From: Anita Gardner
Sent: 30 April 2019 15:50
To: Lynnyrd Wolfe
Subject: FW: R/72/19/PL - 2 New Dwellings - 6 Manor Road, Rustington
Attachments: 6manorproposedplans rev1.pdf; desacc6manor rev1.pdf; 6 manor street scenes for height.pdf; 6manorproposedsite rev1.pdf; 6manorproposedelevs rev1.pdf

I have started to receive representations on the above application. And it is evident that there are discrepancies in the plans submitted. Please can you let me have the following:

DRAWING No: DS/6MANOR/03 rev 1

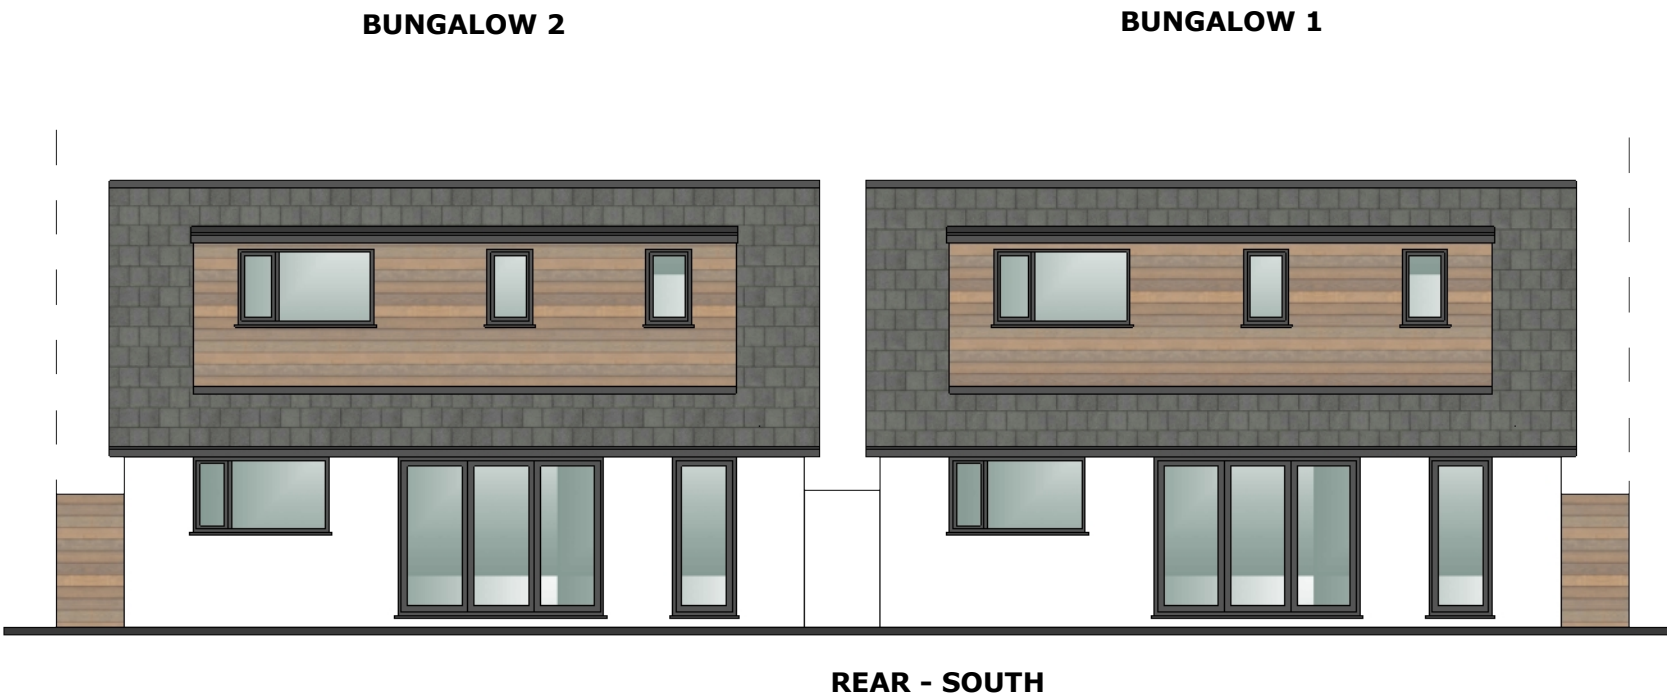
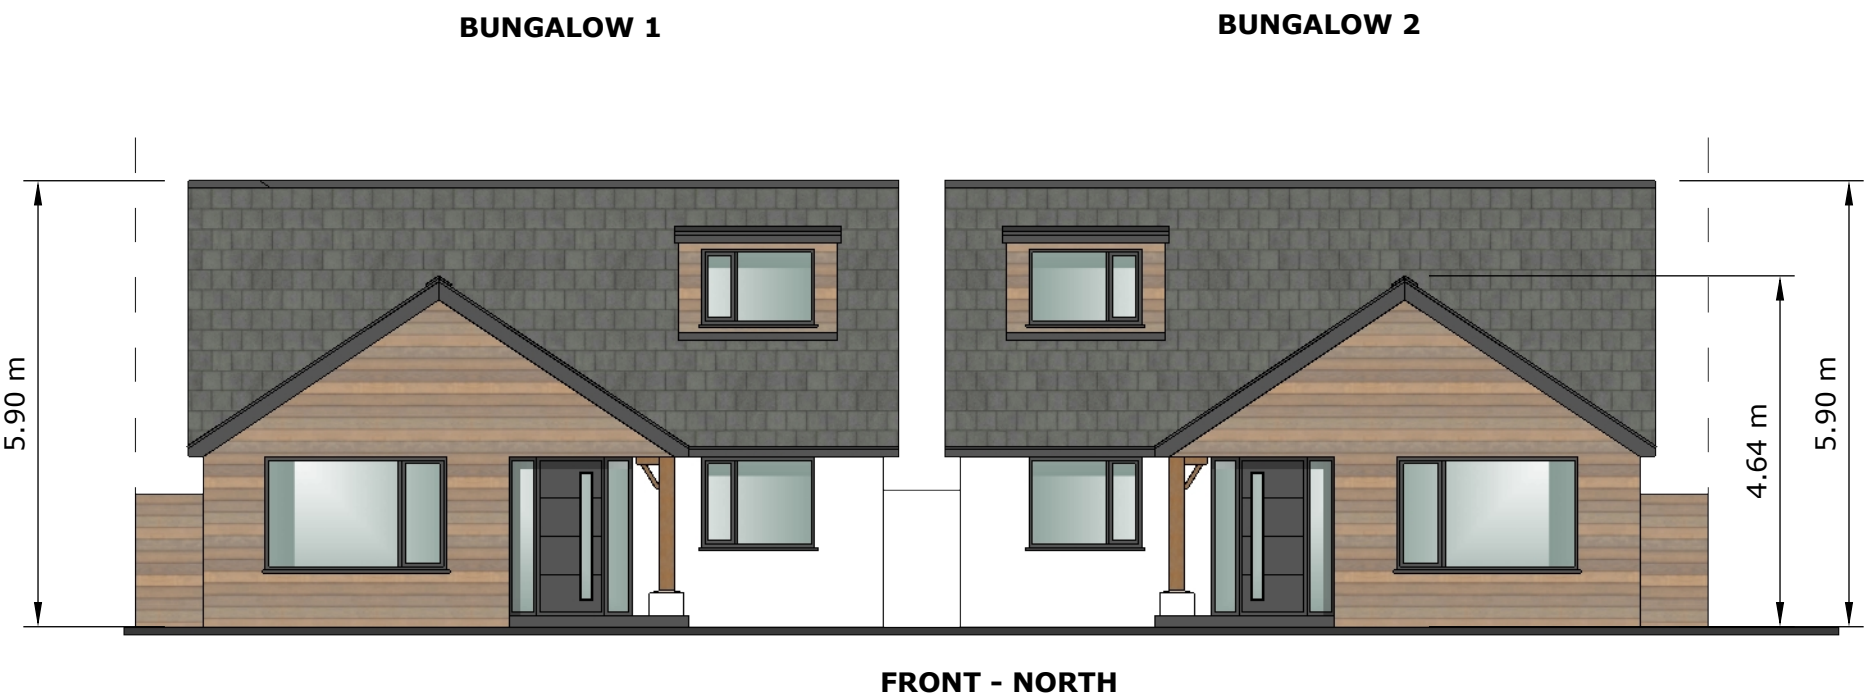
- The Ridge Height – the design statement states the ridge height will be 6.2m but the elevation drawing show a height of 6.62m and the elevations appear to scale the larger height, a difference of 0.42m.

- The roof plan on the site drawing does not show the front and back dormers but shows barn hips at opposite ends of each chalet bungalow, however the elevation drawing shows full height gable ends and no barn hips.

- The first floor plan shows a side window in Bedroom 2 which is not included in the elevations.
- The application forms state that there are no trees on the site but there are numerous trees of different size and species, mainly where the building plots are proposed, along with a very high hedge screening to the full width of the back boundary of the site. The forms are therefore incorrect and the trees should be indicated on the 1:200 block plan to show which are being removed and clarification given as to whether the rear hedging is being retained.

Dear Anita,
Please find amended details attached.
